Boston Alternative Energy Facility – PINS reference: EN010095

Lincolnshire Wildlife Trust's submission for deadline 4 of the above planning application. Comments provided relate to documents:

- **9.30 Without Prejudice Habitats Regulation Assessment. Derogation Case: Compensation Measures.**
- **9.12 Outline Marine Mammal Mitigation Protocol (MMMP).**
- **9.14 Addendum to Environmental Statement Chapter 17 and Appendix 17.1 - Marine Mammals**

TITLE
WHARF GENERAL LAYOUT
DRAWING
FIGURE 5.2 - SHEET 1 OF 3

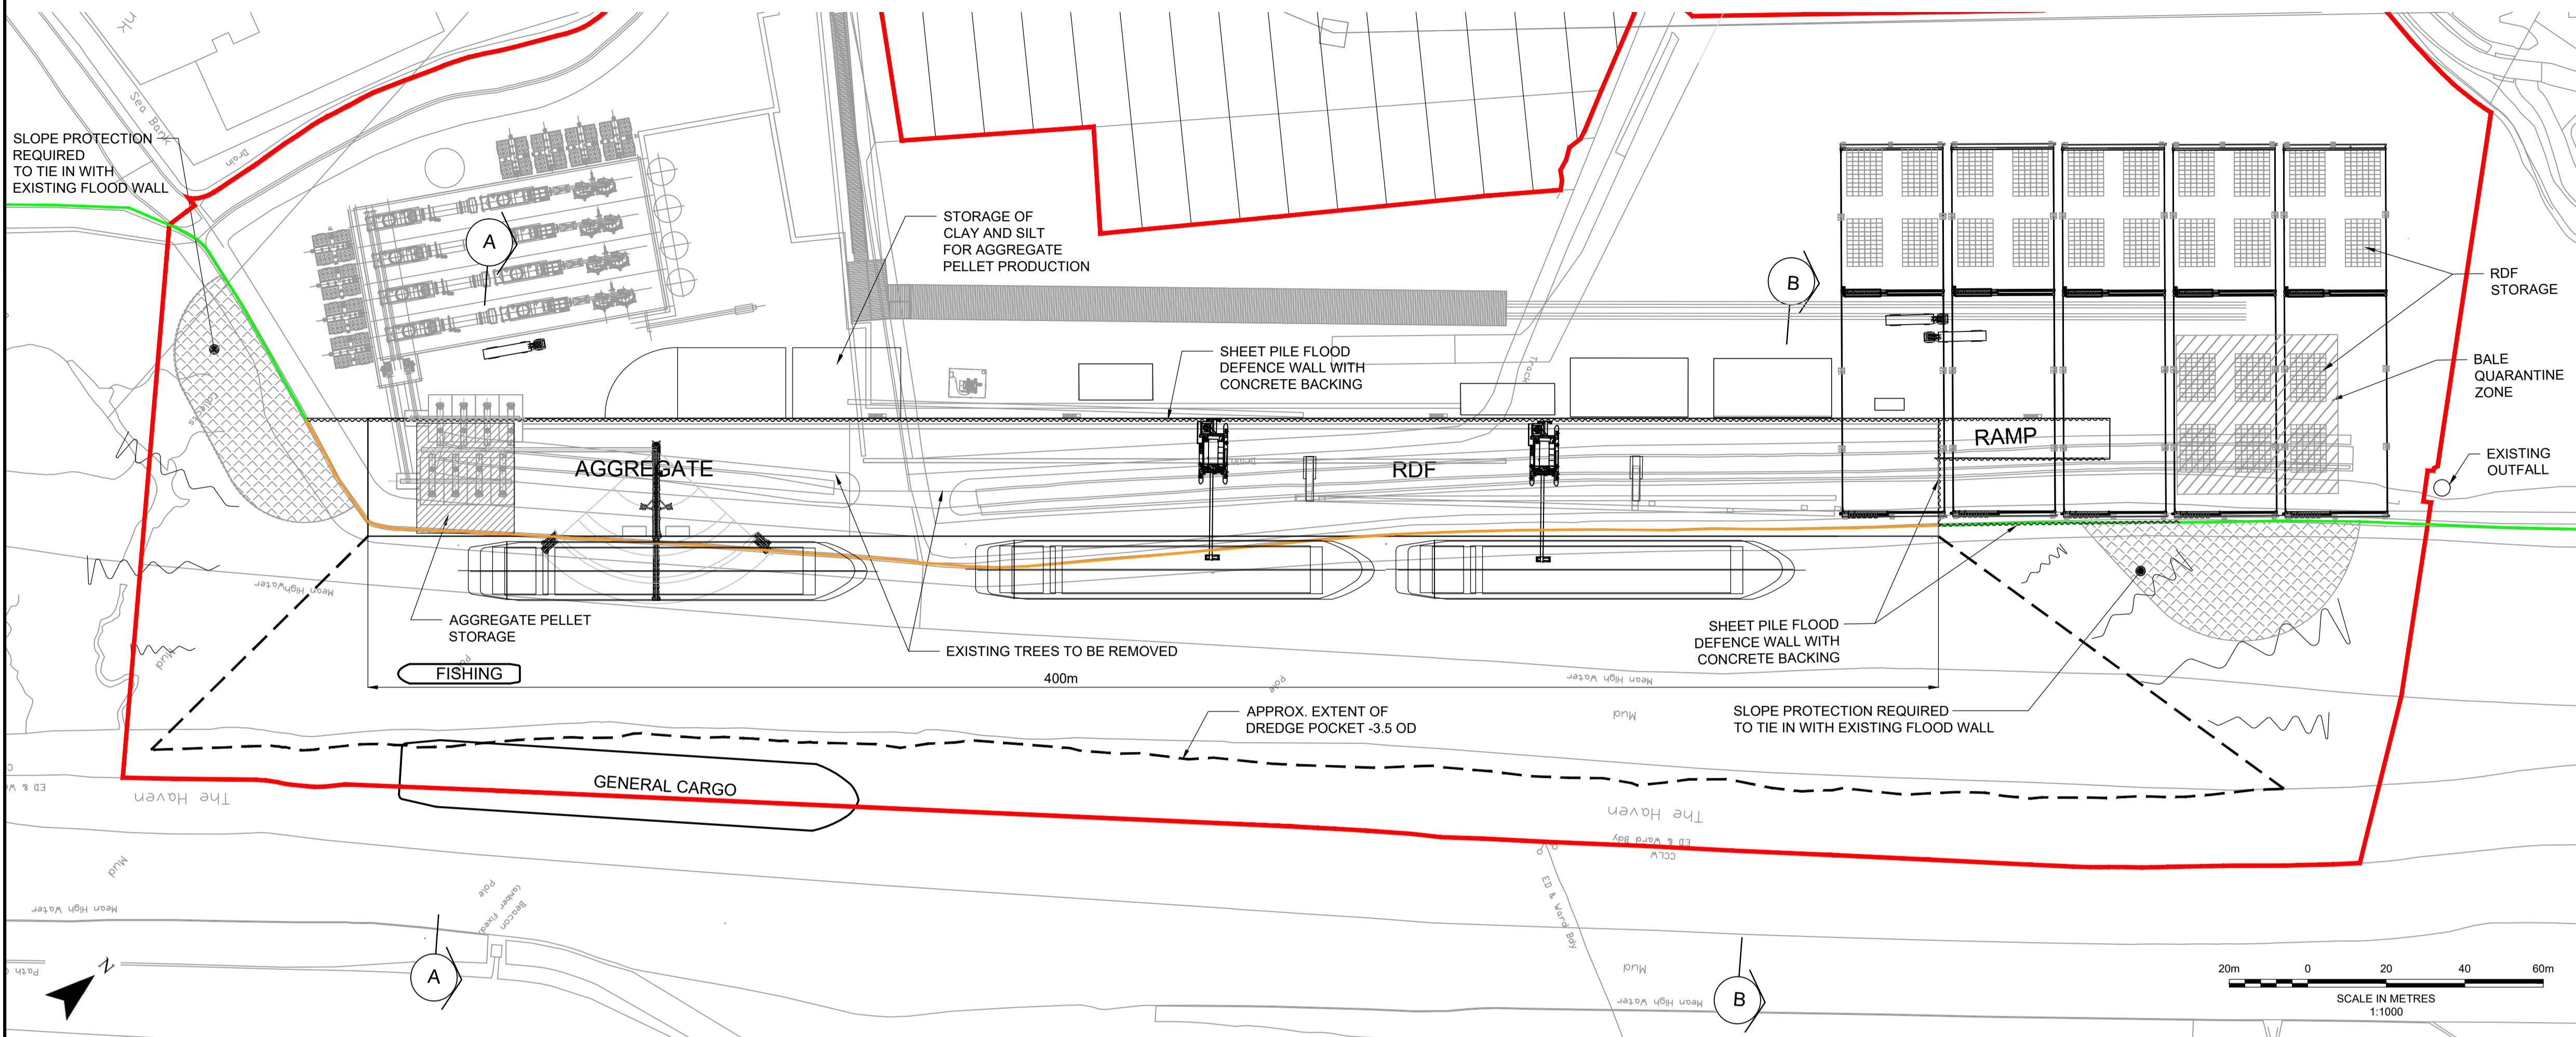
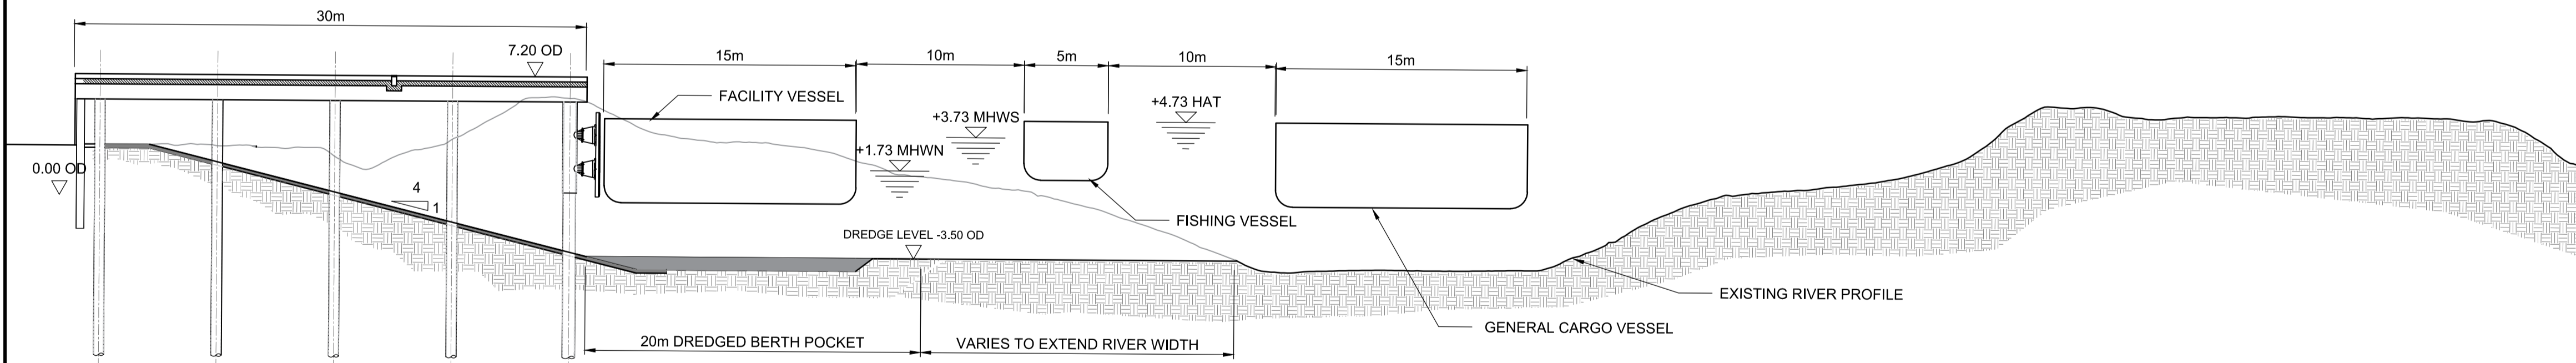
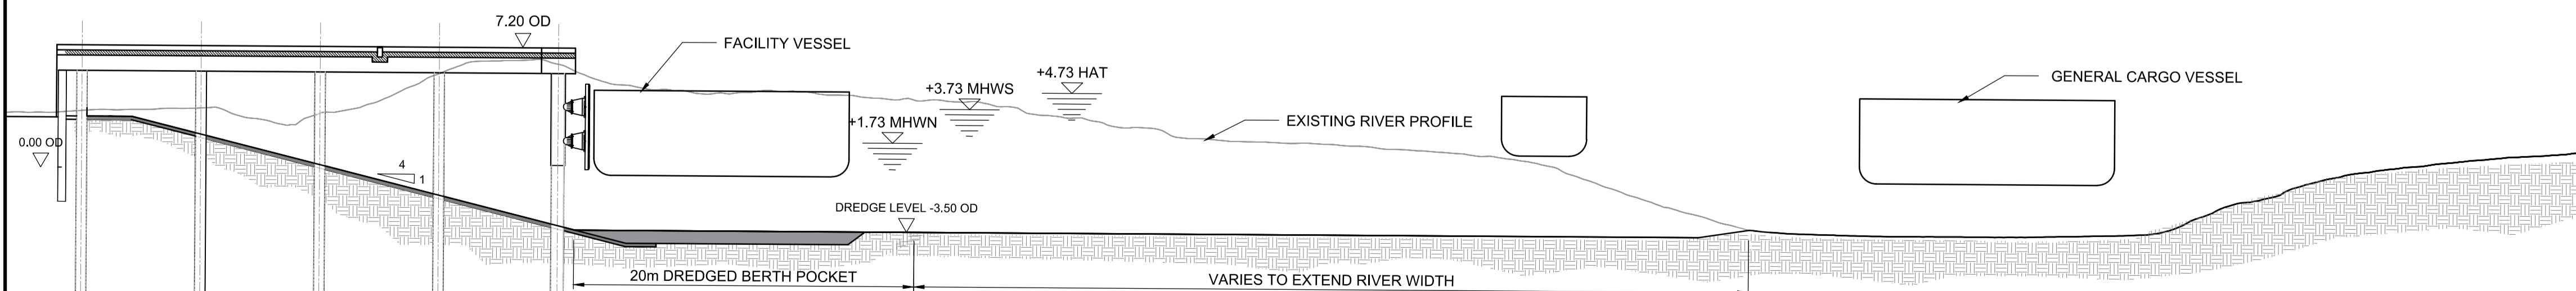
We believe that specific piling methodology and further underwater noise modelling for the proposed BAEF development, and assessed for the potential effect it may have on harbour seal, is still required for reasons outlined below.

We also question if it would be possible to limit piling activity to low tide periods only, to further reduce potential harm.

In their deadline 2 submission relating to Marine Mammals [REP1-025, REP1-027], Natural England, at item three, questions whether soft start up procedures will be appropriate for the specific type of piling being used at the proposed wharf site. The applicant should provide information to support their use of this mitigation procedures relating to this specific site.

Natural England also states that updated guidance referring to the use of MMOs is available. Again, underwater noise modelling specific to the BAEF application should be undertaken to determine the Permanent Threshold Shift (PTS) Zone, rather than solely adopting the 500m MMO observational zone. The applicant has noted that the 500m observational zone cannot be fully applied at the development site due to the geography of the Haven near the proposed wharf. The reasons for the PTS range for harbour seal being set at 90m should be qualified by the applicant.

PAM is generally used to detect cetaceans in low visibility conditions rather than pinnipeds like harbour seal. Therefore, this method of mitigation is not appropriate for this species. The Trust suggests that during low visibility piling operations are halted.
